Date 31 October 2019

RE: 6/2019/1411/MAJ – Plot 5100, Mosquito Way, Hatfield Business Park, Hatfield, AL10 9WN

We understand this application seeks full planning permission for a major development, and we have assessed the Flood Risk Assessment & Drainage Strategy prepared by Baynham Meikle Partnership Ltd, project reference JD/12690, report status 4th Issue, dated September 2019, submitted to support to this application. However, the information provided to date does not provide a suitable basis for an assessment to be made of the flood risks arising from the proposed development.

Drawing file: P21001-BMP-ZZ-ZZ-DR-C-0104 Rev.C05 - Proposed Drainage and Levels Plan.pdf

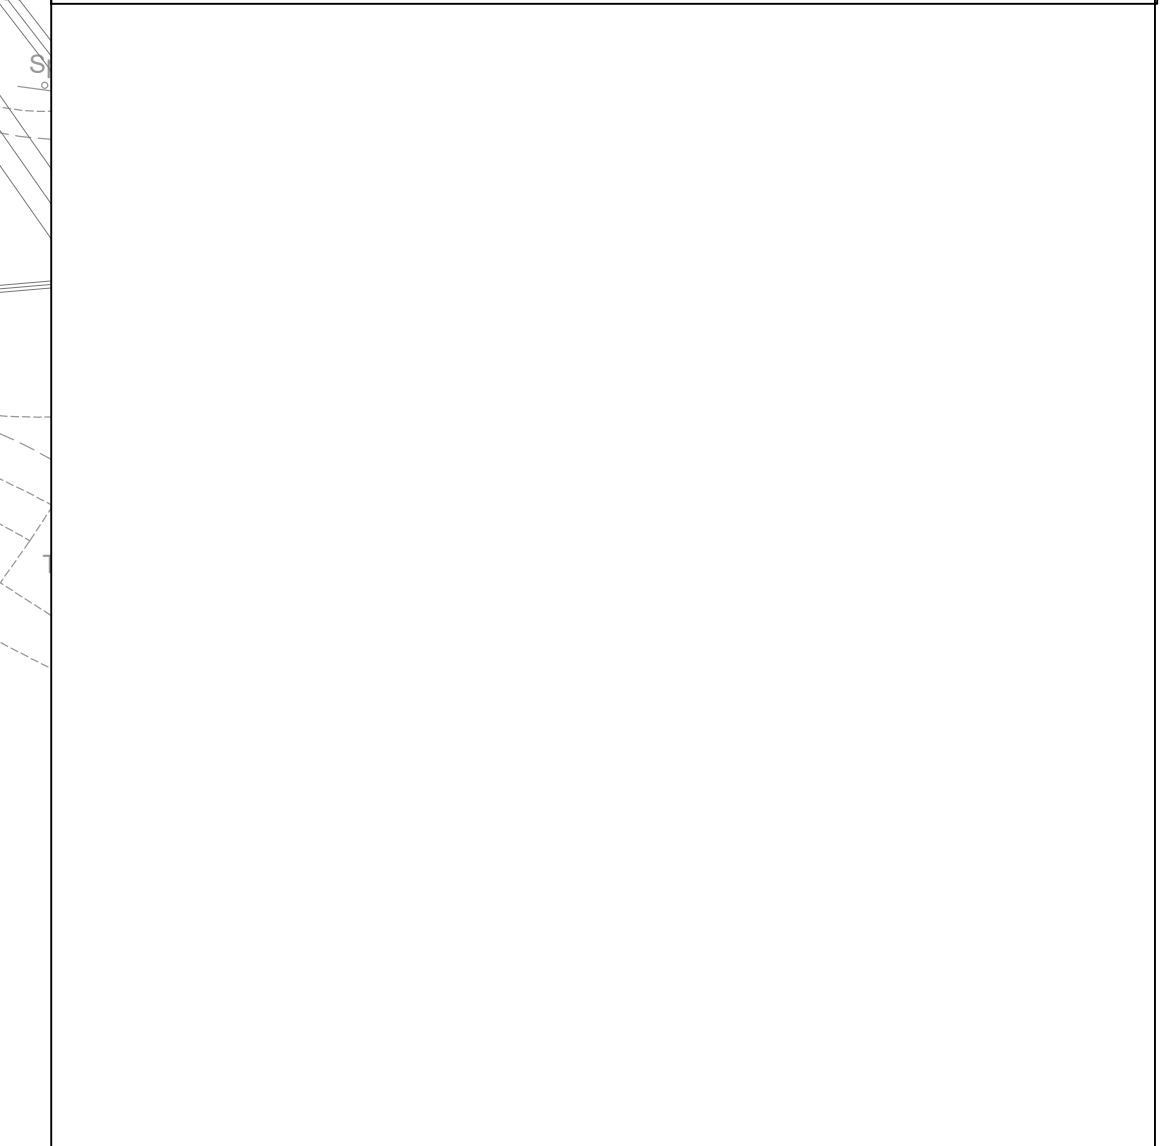
1. We acknowledge that the applicant has submitted an updated drainage strategy limiting the final surface water discharge rate from the site to 123l/s.

However, based on the latest response provided by the water company '*Thames Water has identified an inability of the existing SURFACE WATER infrastructure to accommodate the needs of this development proposal*'.

As per Thames Water advice 11 l/s should be accommodated for the final surface water discharge from the site, which corresponds to Greenfield runoff rates.

Therefore, we would strongly advise that the proposed drainage strategy should be revised and appropriate discharge rates should be proposed.

We would like to highlight that the submitted modelling, the drainage layout and the informal flooding areas drawing will have to be updated in line with the above.

3. Based on the submitted information, we do not believe that an appropriate SuDS management train has been proposed or even assessed. We would strongly refer to the latest response from Environment Agency submitted on the planning portal.

We would strongly advise the applicant that as a minimum two SuDS management stages should be provided for all the runoff from the proposed access road, internal roads and parking spaces.

We understand that the applicant intends to include permeable paving with sub-base and retention petrol interceptor to provide a level of treatment. However, this does not provide an appropriate level of SuDS management stages for the entire site.
